Application No: BE/59/21/PL
Site Address: 339 Chichester Road Bersted PO21 5AN
Description of works: Replacement of blockwork boundary wall with fence and new vehicular access (resubmission of BE/149/21/PL).

Thank you for your internet representation made on 7th May 2021 which has been recorded as an objection with the comments as follows:

SITE PLAN - SHOWING VISIBILITY SPLAYS
1:500 SCALE (at A3)

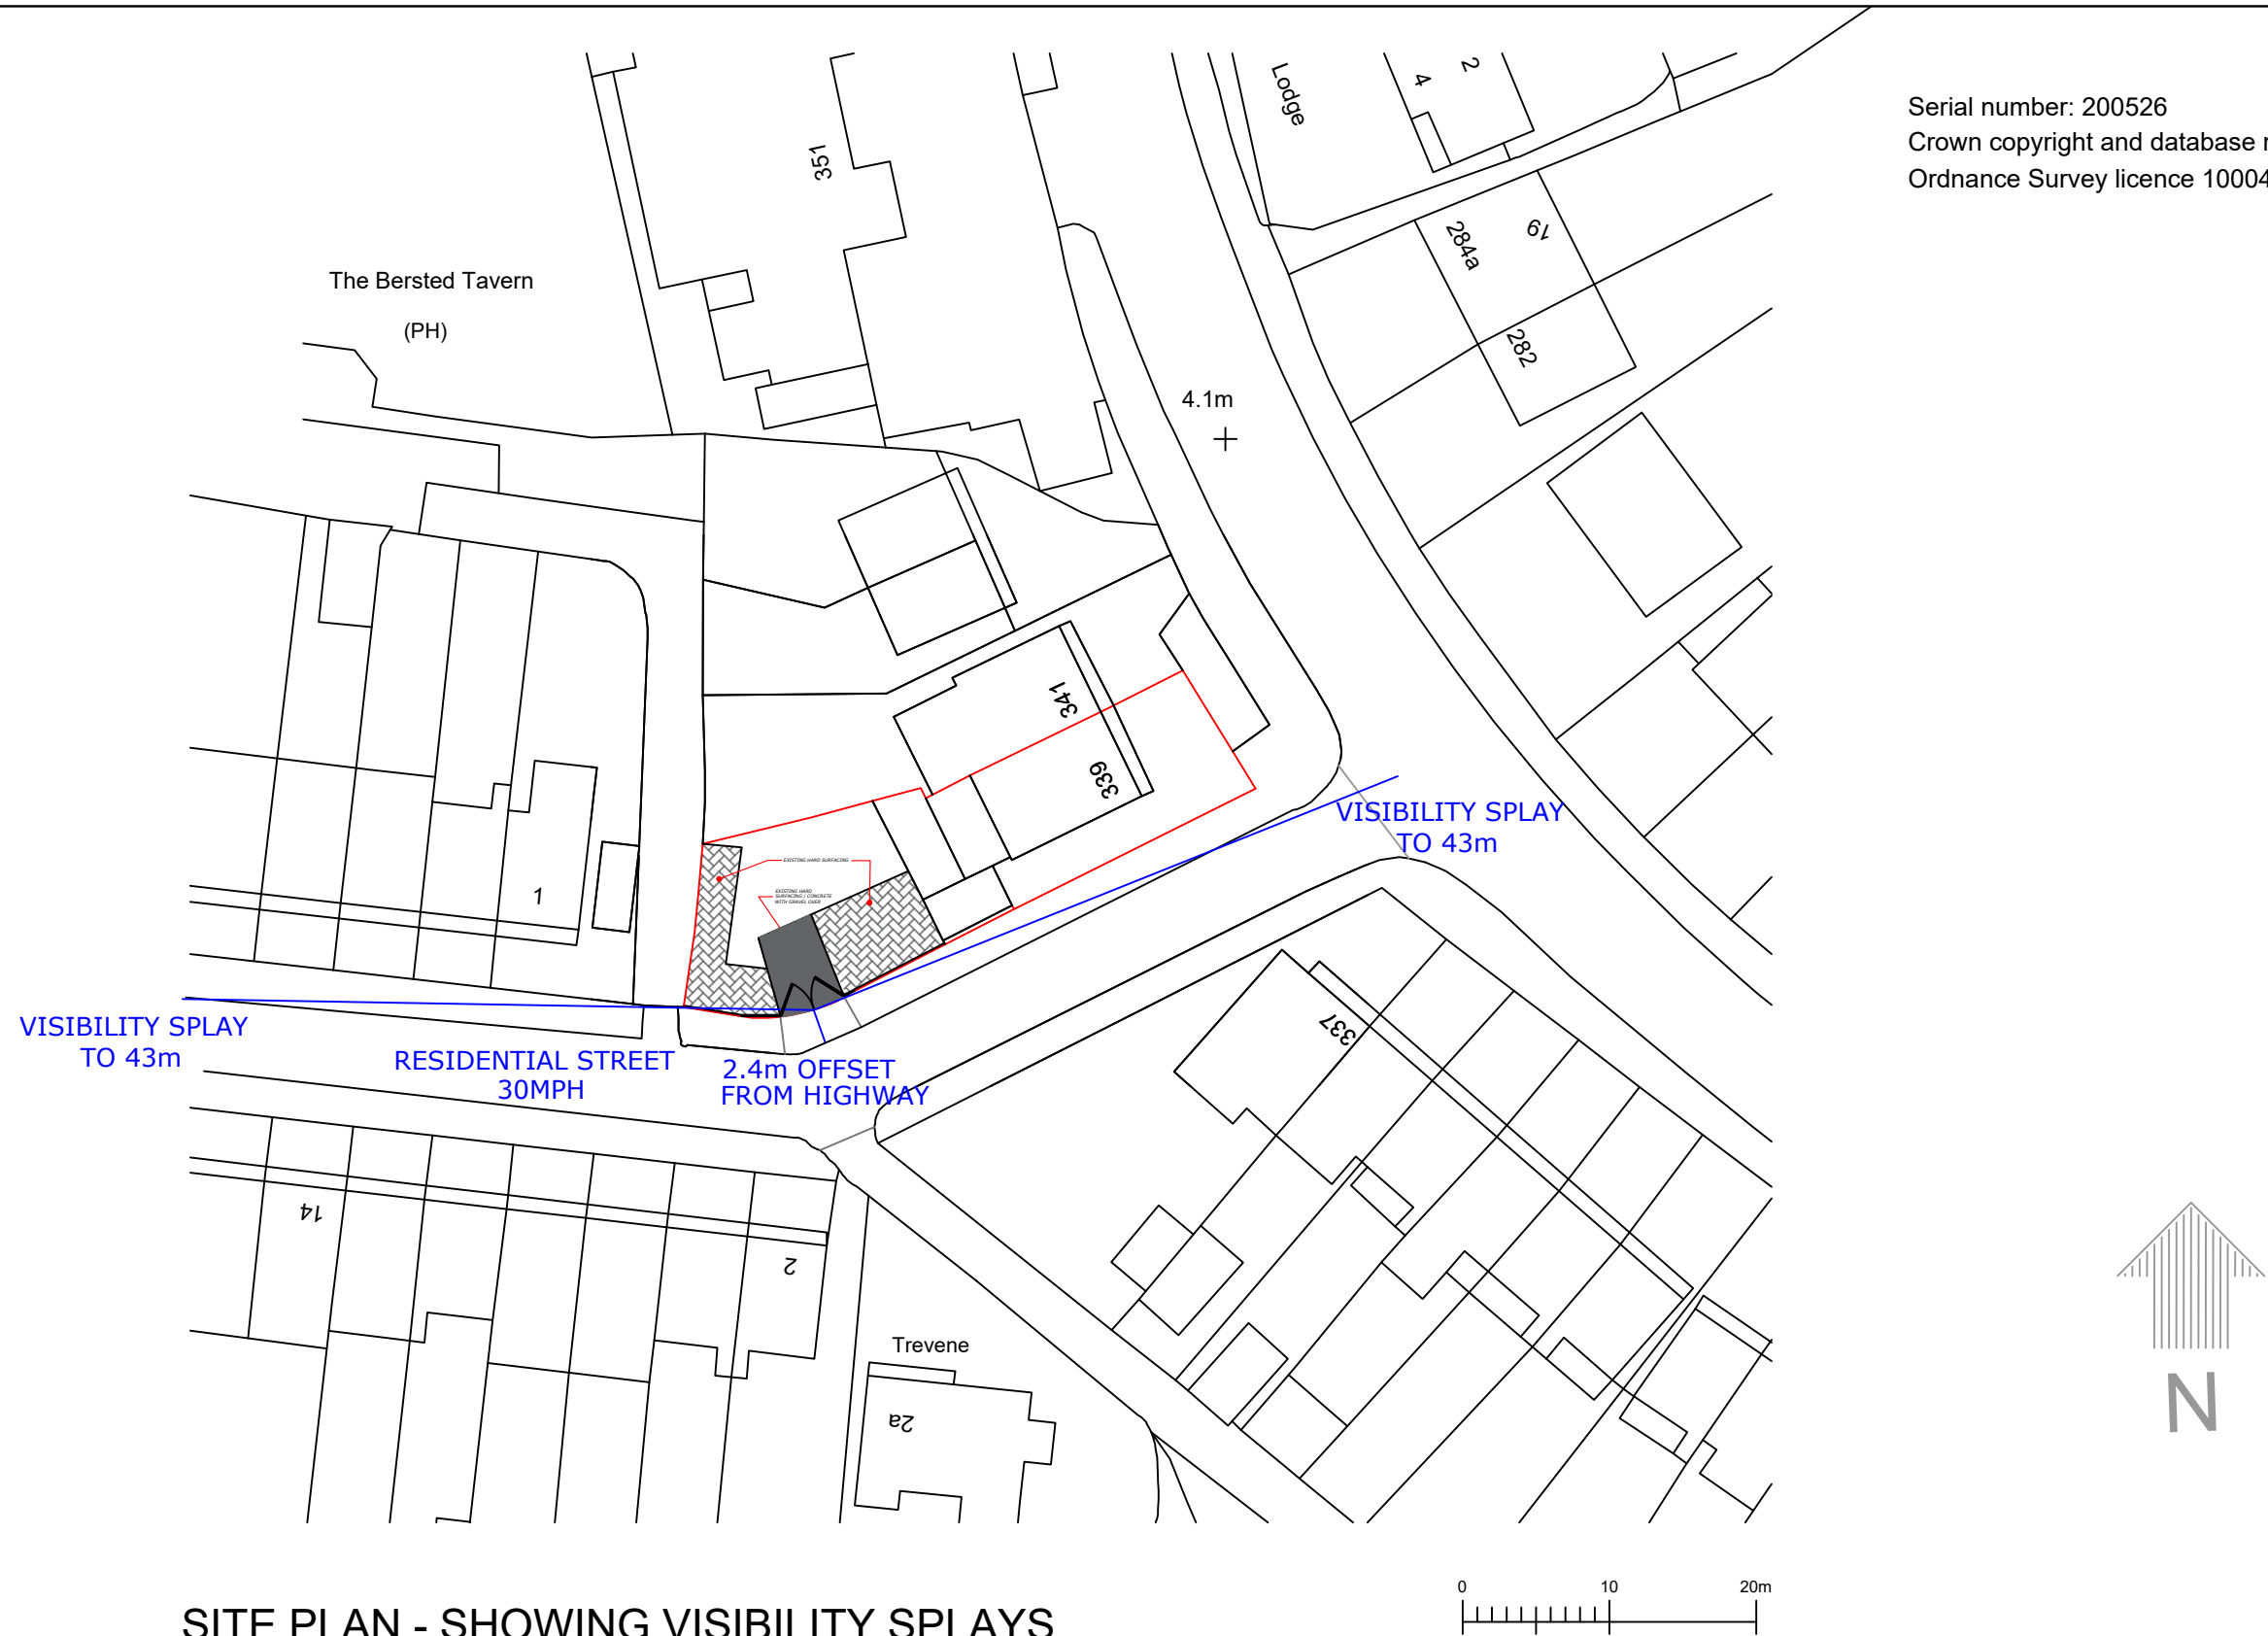
The lack of visibility due to the sighting of the proposed access on a bend would cause risk to pedestrians and other road users. Also the proposed entrance is opposite another junction. Bedford Avenue is a busy road at certain times of day and is used by pedestrians from local area to get to the Tesco Express. School children use lane opposite on foot and on bikes which is an additional risk. Bedford Avenue is used as a shortcut by motorists, sometimes at speed, when the B2259 is slow. For children who scoot on the pavement around the bend would not see or be prepared for a vehicle exiting from the side of this property where there has never been a drive before. The current fence around the property is too high for a vehicle to pull out safely onto the pavement. The property already has ample parking at the front which is never full. I can see no valid reason for this application to be granted with so many obvious risks to the public.
